RE: Response to Exhibition of Sydney Opera House (SOH) Building Renewal Program – Concert Hall Upgrade and new Creative Learning Centre (SSD 8663)

ATTACHMENT A: SYDNEY OPERA HOUSE BUILDING RENEWAL PROGRAM

CONCERT HALL & CREATIVE LEARNING CENTRE HERITAGE ASSESSMENT

1:50

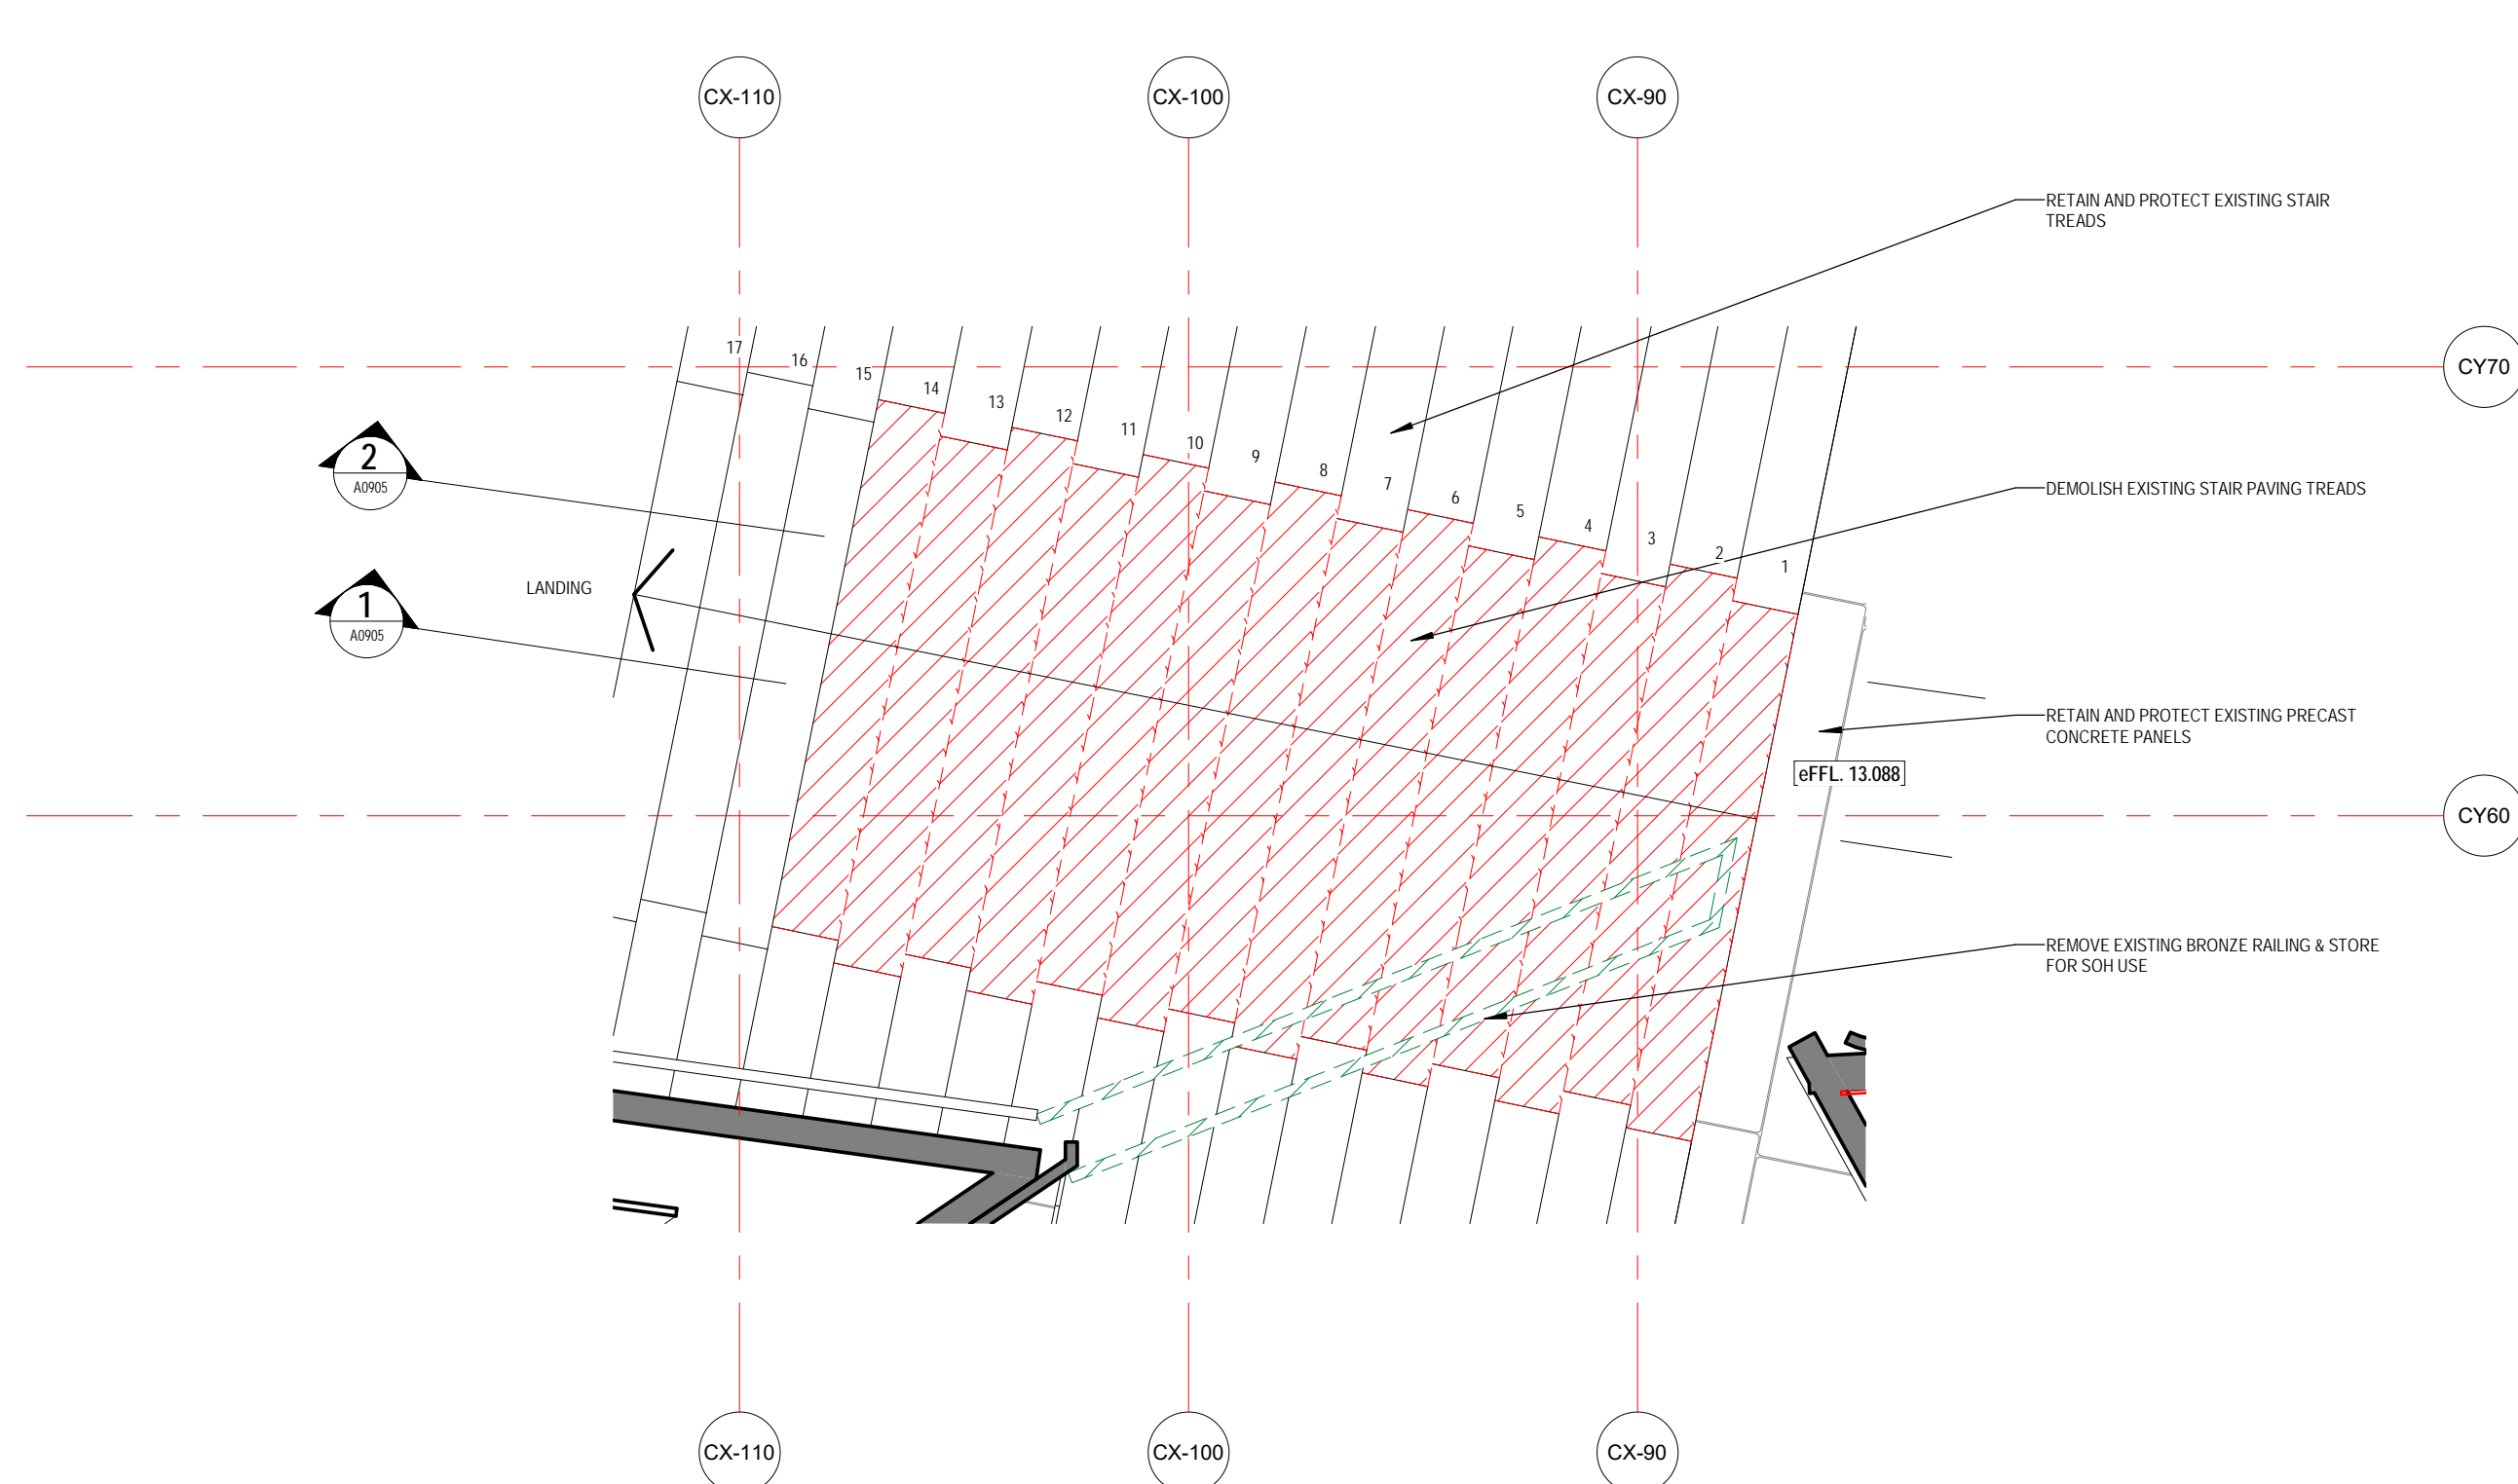
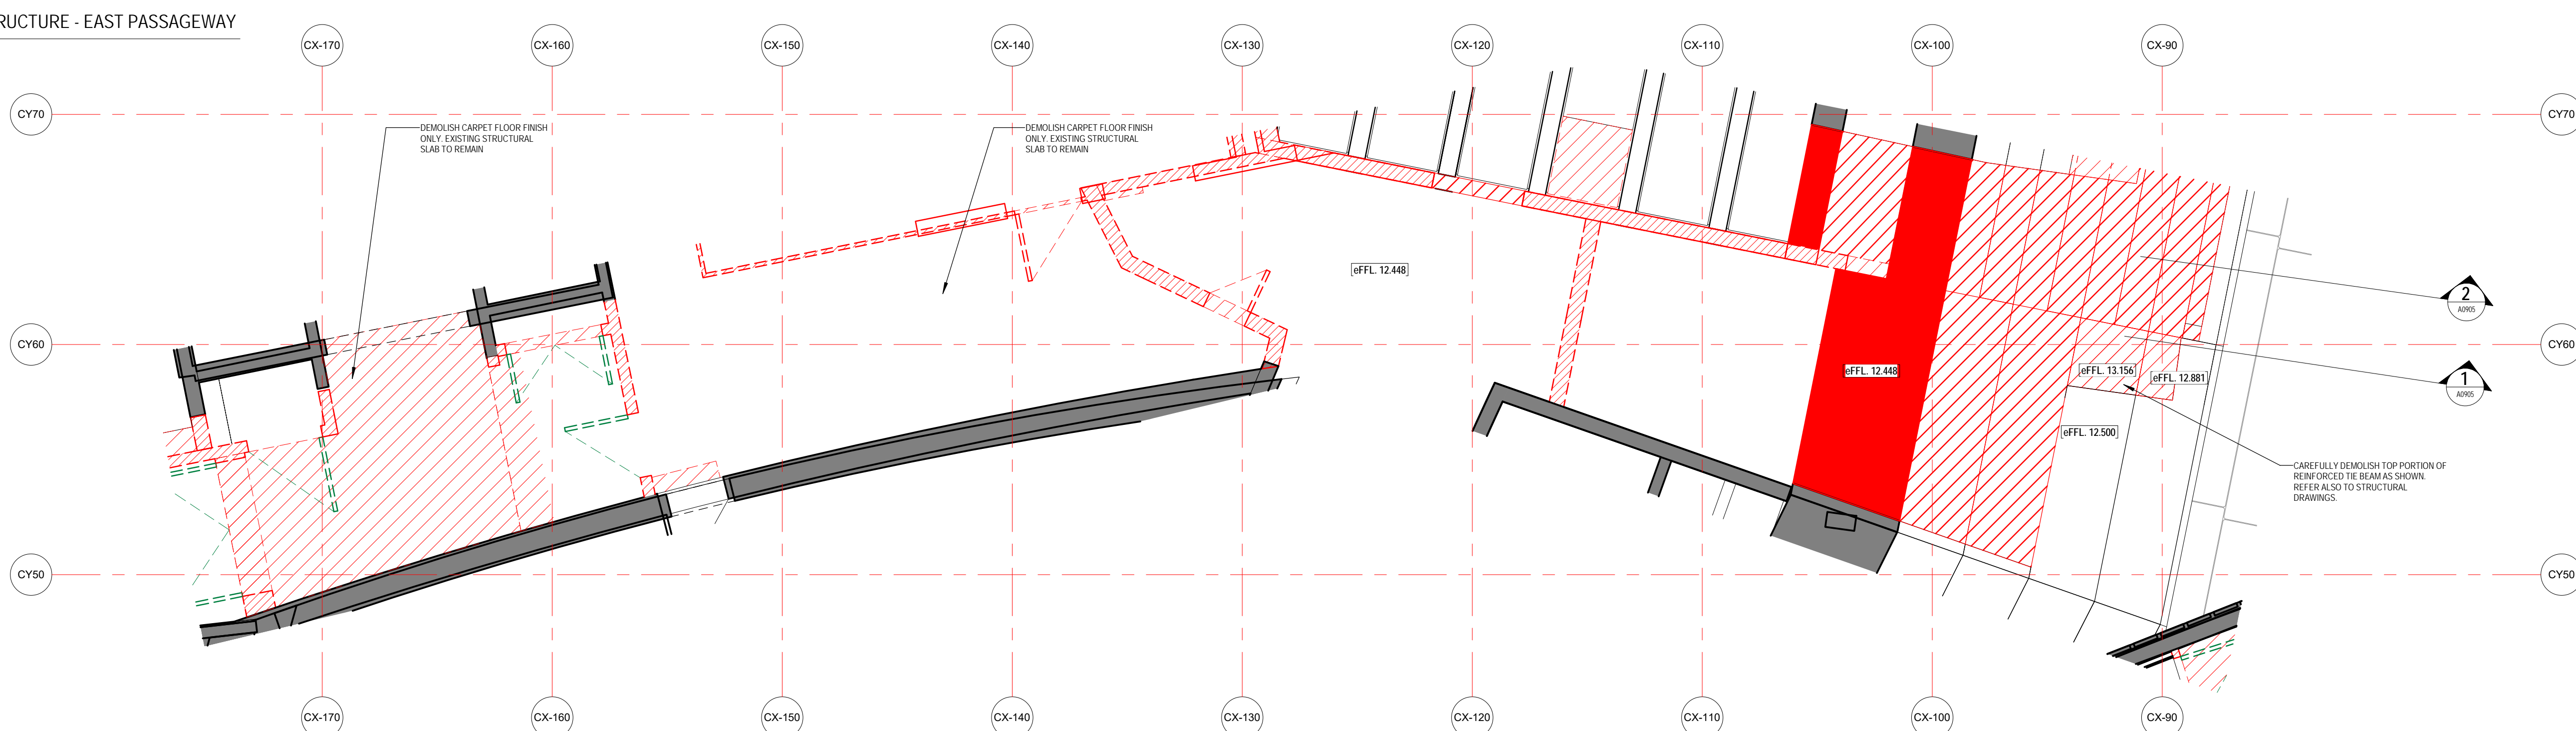
- 3.4 The new passageway entrance is proposed to be located centrally within the eastern foyer stairs. It is noted that the passageway is only proposed on one side of the Concert Hall (eastern), with no works occurring on the western side foyer stairs (apart from new handrails). The proposed location of the passageway entry has high visual impacts as it divides the distinctive broad sweep of stairs which step around the Concert Hall. It also narrows the stair access either side of the passageway and diminishes the grandeur of the space as patrons ascend around the Concert Hall.

- 3.10 The design introduces prefabricated bronze panel elements in a stepped configuration to clad the full length of the eastern wall of the new passage. Whilst the wall configuration reflects the brush box panel cladding of the auditorium in the side foyer above, the use of the bronze material introduces a new design aesthetic to the space. The recent passageway provided to the JST side foyer utilises concrete and timber which is more consistent with the palette of materials used throughout the SOH, and which is also more visually recessive. The extensive use of the bronze panelling in this area is not appropriate and should be reconsidered to better align with the consistent palette of materials of the SOH. The panelling should be more visually recessive.

- 3.12 Bronze panelling is also proposed for the western side of the passageway entry. This should be revised to match an alternative wall cladding to be chosen for the eastern wall.

- 3.14 The proposed works will have an adverse impact on significant form, fabric and structure in this area. The installation of the passageway requires removal of a series of precast granite plank steps and concrete structure below, which will result in a major physical intervention. The steps will be removed in whole lengths (at the expansion joints) and new precast granite steps are proposed to be installed to have finished edges at the junction of the new passageway and the staircase.

- 3.16 The proposed works also involve new concrete finishes. A site visit undertaken by the Heritage Division in January 2019 noted similar works in the JST Side Foyer passageway which were patchy, and the concrete colour mismatched. For some heritage places, it could be argued that the difference in colour identifies new works. However, given that the high-quality finish and detailing in the SOH are integral to its significance, new works must be matched by equal high-quality craftsmanship to ensure the new works are seamlessly integrated into the design. Therefore, any new

- 3.17 The following condition is included in the HIS, *the use of bronze panelling on the southern wall in the Caves area (Level 2) should be tested and reviewed once the other walls are stripped back, by the Opera House's Conservation Council, Eminent Architects Panel and heritage architect, to determine its appropriateness (Pg104)*. However, the extensive use of bronze panelling within the passageway introduces a new design aesthetic to the space. A panelling treatment consistent with existing panelling used within the SOH should be proposed in consultation with the Heritage Council to ensure the 'natural' visually recessive palette of materials and colours is retained and respected.

- 3.18 Any new steps installed must match the existing in both form and finish. This should be determined in consultation with the nominated heritage consultant working closely with an experienced precast concrete craftsperson to ensure colour and form are matching. Removed fabric should be retained, modified and reused where possible.

- 3.19 Any new elements proposed, including concrete finishes, must match the existing in both form and finish. This should be determined in consultation with the nominated heritage consultant working closely with an experienced concrete expert to ensure seamless consistency, to the satisfaction of a Heritage Council delegate.
